KIRKLEES METROPOLITAN COUNCIL INVESTMENT & REGENERATION SERVICE

DELEGATED DECISION TO DETERMINE APPLICATIONS FOR CONSENT, AGREEMENT OR APPROVAL REQUIRED BY CONDITION

Reference No:	2026/44/90254/W
Site Address:	land at, Vanguard Processing Equipment, Spa Fields Industrial Estate, Slaithwaite, Huddersfield, HD7 5BB
Description:	Discharge of details reserved by conditions 3 (Phase II Intrusive Site Investigation Report), 7 (EV Charging Point), 8 (retaining structures foundations), 9 (CEMP), 10 (retaining walls and boundary treatments details), 11 (invasive species protocol), 12 (foul, surface water and land drainage scheme), 13 (1 in 100 year storm events), 15 (oil/petrol interceptor), and 17 (bat and bird box) on previous permission 2021/90605 for erection of an industrial building (B1(c) use)
Recommending Officer:	Farzana Tabasum

DECISION – Discharge of Condition – Approve

DETAILED SECTION D-D - CALLOUT

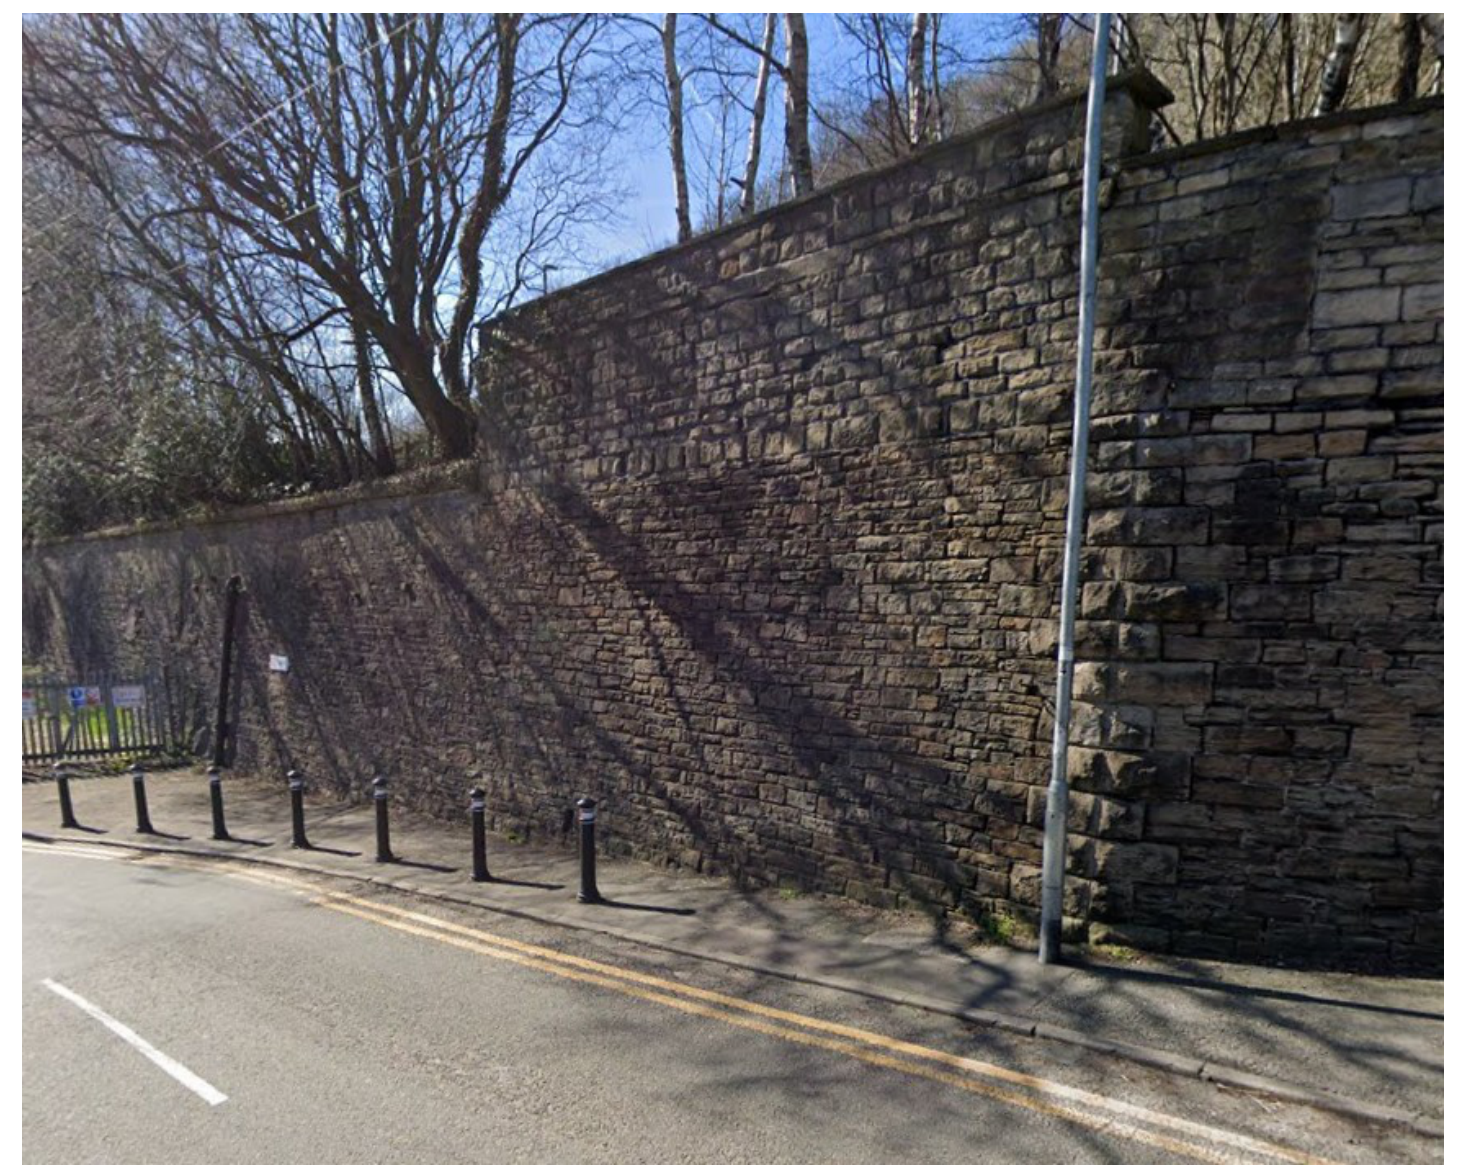
The Canal & River Trust (C&RT) initially advised in their consultation dated 12/02/2026 that whilst the submitted information had been reviewed, additional cross-sections showing the relationship between the proposed retaining wall and the canal edge, ideally including the canal at full depth, were required. C&RT advised that this information was necessary to enable the calculation of the zone of influence and to determine whether the proposed retaining walls could result in loading upon the canal wash walls, potentially affecting local land stability. Accordingly, C&RT advised that condition 8 should not be discharged until the additional information had been submitted and assessed.

Whilst C&RT initially requested further information to enable an assessment of the potential loading effects on the canal wash walls, this information was subsequently provided by the applicant. Following review of the additional details, C&RT confirmed that they were satisfied that the proposed retaining wall detail and foundations would not significantly impact upon the canal structure and raised no objection to the discharge of the condition.

Following the submission of additional information, including revised retaining wall details and cross-sections, C&RT confirmed within their consultation dated 04/04/2026 that they were satisfied that the retaining wall detail and foundations relative to the canal would not significantly impact the canal structure. C&RT therefore confirmed that sufficient information had been provided to allow the discharge of condition 8.

Having regard to the submitted drawings and the specialist advice provided by the C&RT, it is considered that sufficient information has been submitted to demonstrate the relationship between the proposed retaining structures and the adjacent canal, and that the proposals would not give rise to unacceptable risks to land stability or the structural integrity of the Huddersfield Narrow Canal.

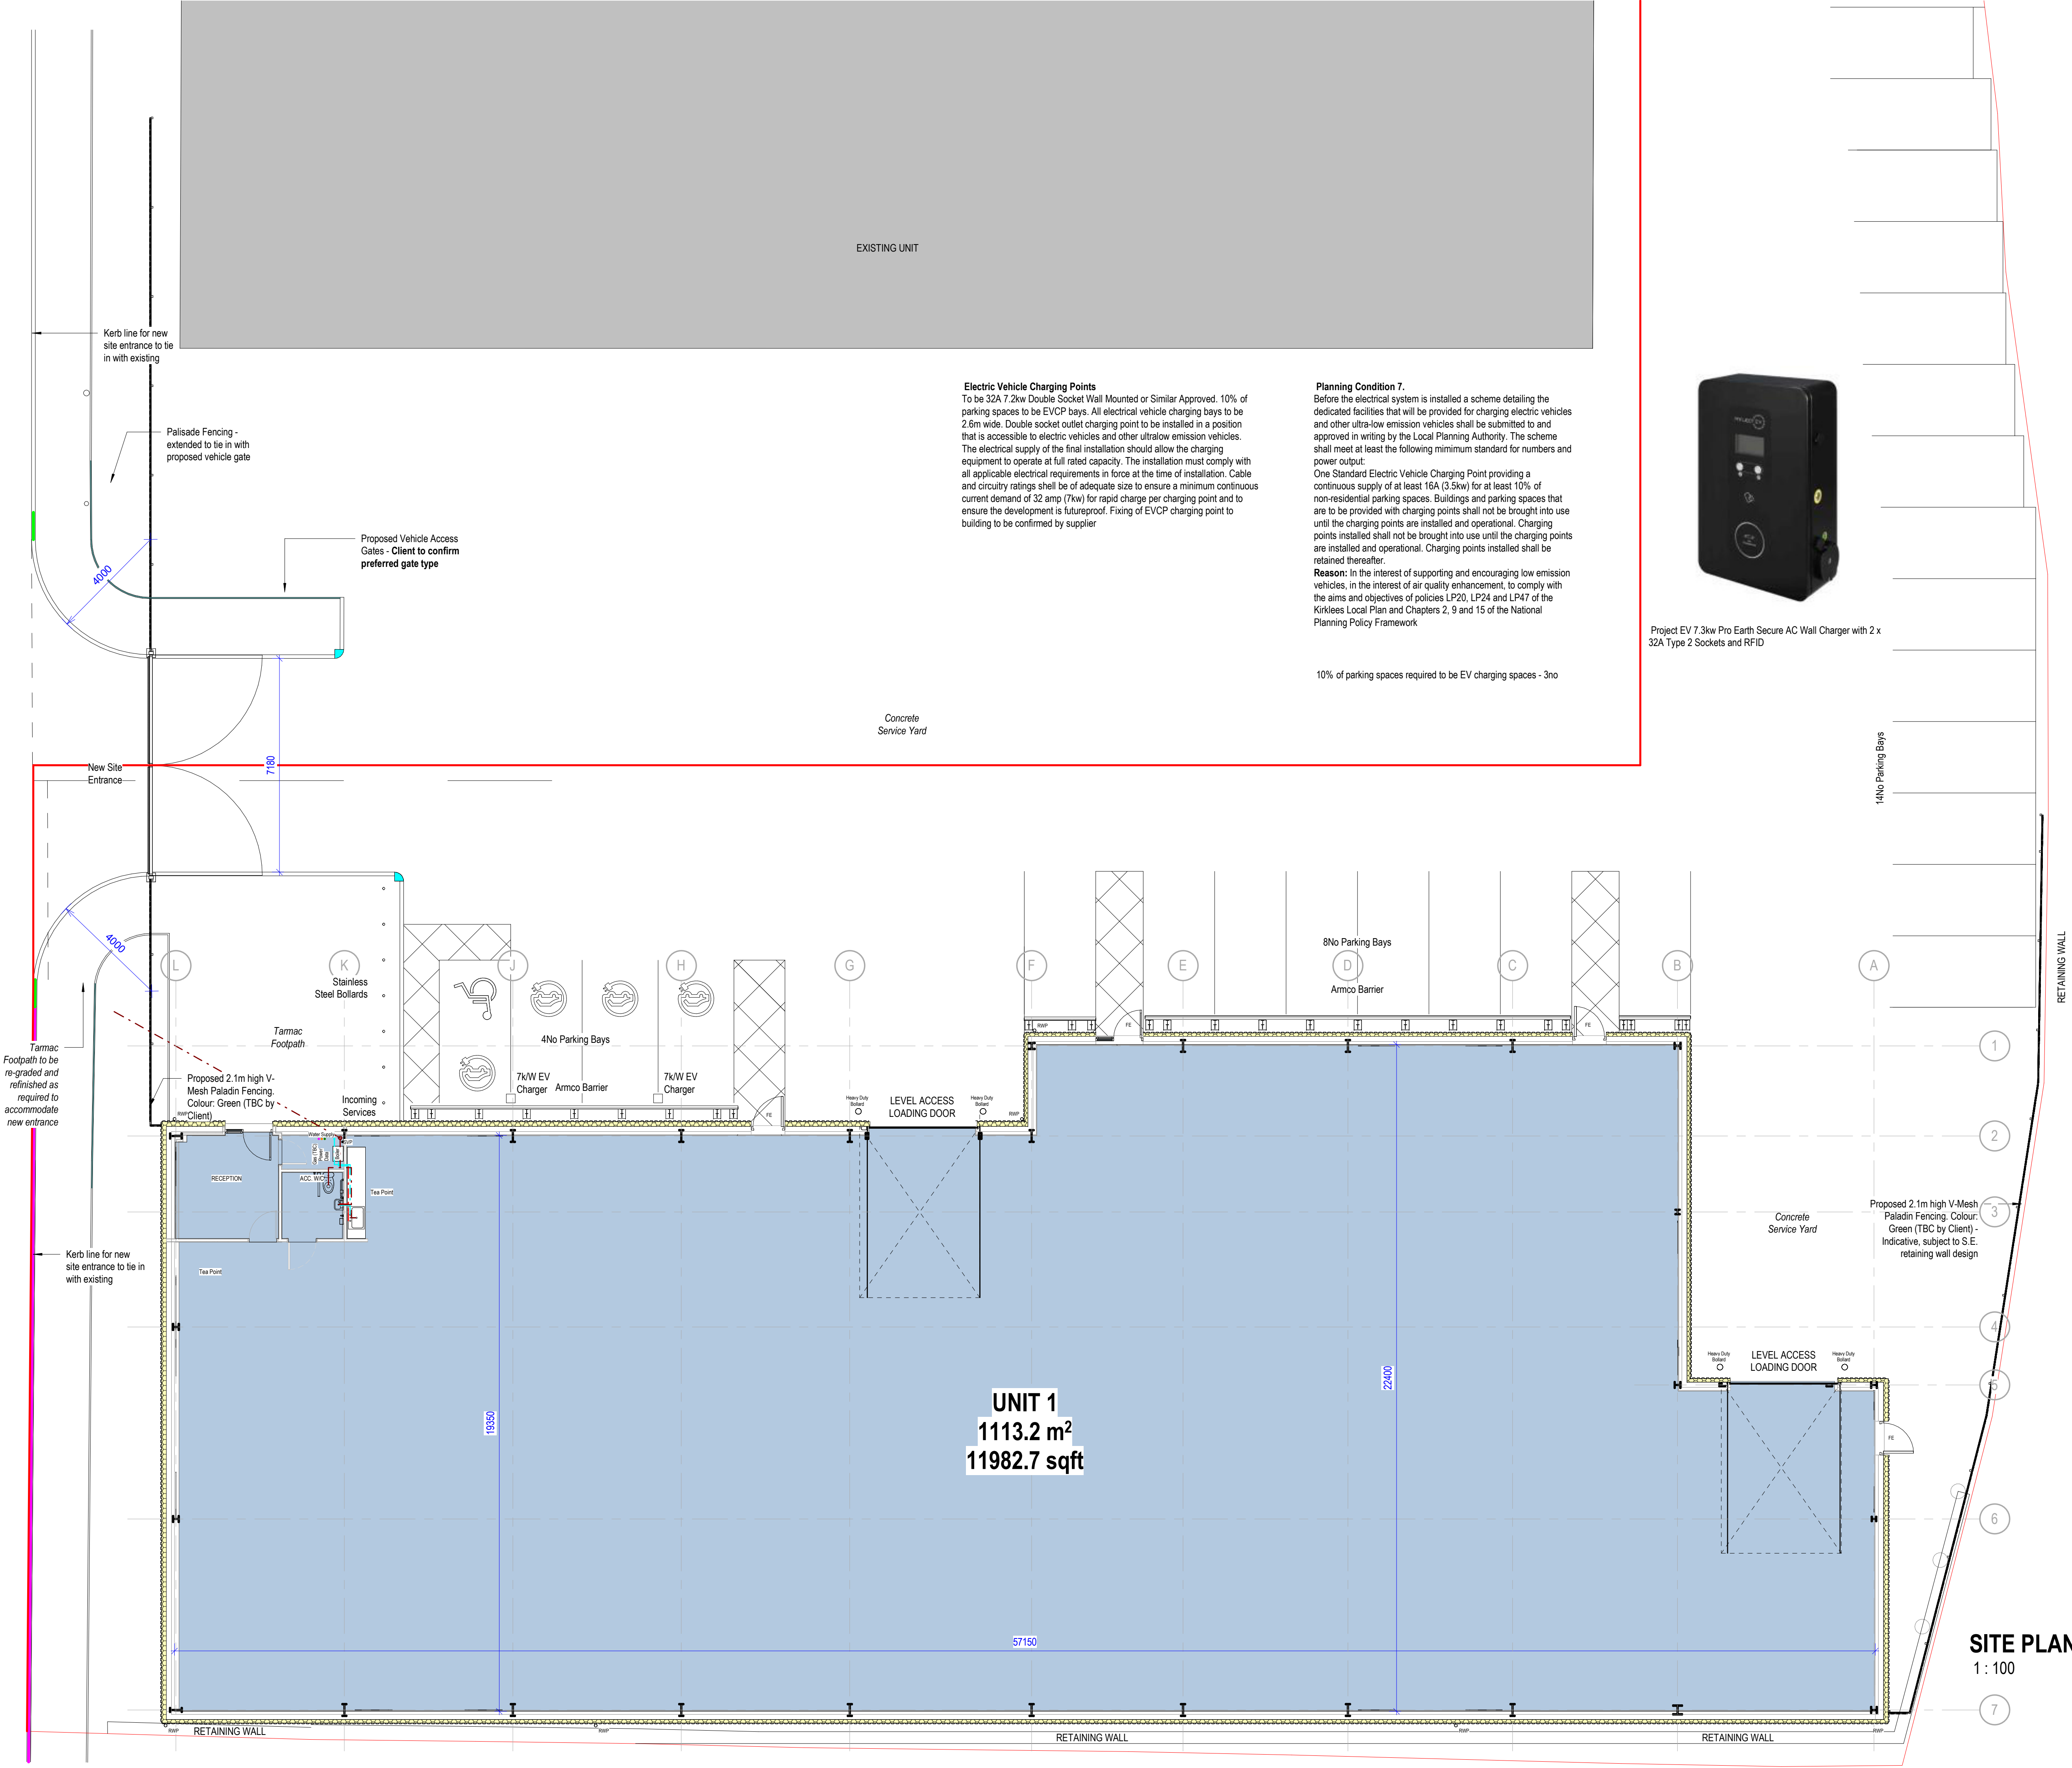
Twenty six parking spaces were approved on the original scheme, as such 10% would equate to 2.6, rounding this off would require three EVCP's. The condition also requires that the approved charging facilities are installed and operational before the building and associated parking spaces are first brought into use and that they are retained thereafter.

The revised submitted proposed site plan identifies the location of four dedicated 7kW electric vehicle charging points through the provision of x2 double port chargers, within the parking area to the front of the industrial building.

The proposed charging point exceed the minimum charging capacity specified by the condition, providing a 7kW, compared with the minimum requirement of a continuous 16A (3.5kW) supply. The submitted scheme therefore demonstrates appropriate electric vehicle charging infrastructure, subject to being incorporated into the development in accordance with the requirements of the condition.

The ongoing requirements of the condition remain applicable, requiring the approved charging points to be installed and fully operational before the building and associated parking areas are first brought into use, with the charging facilities thereafter retained for the lifetime of the development.
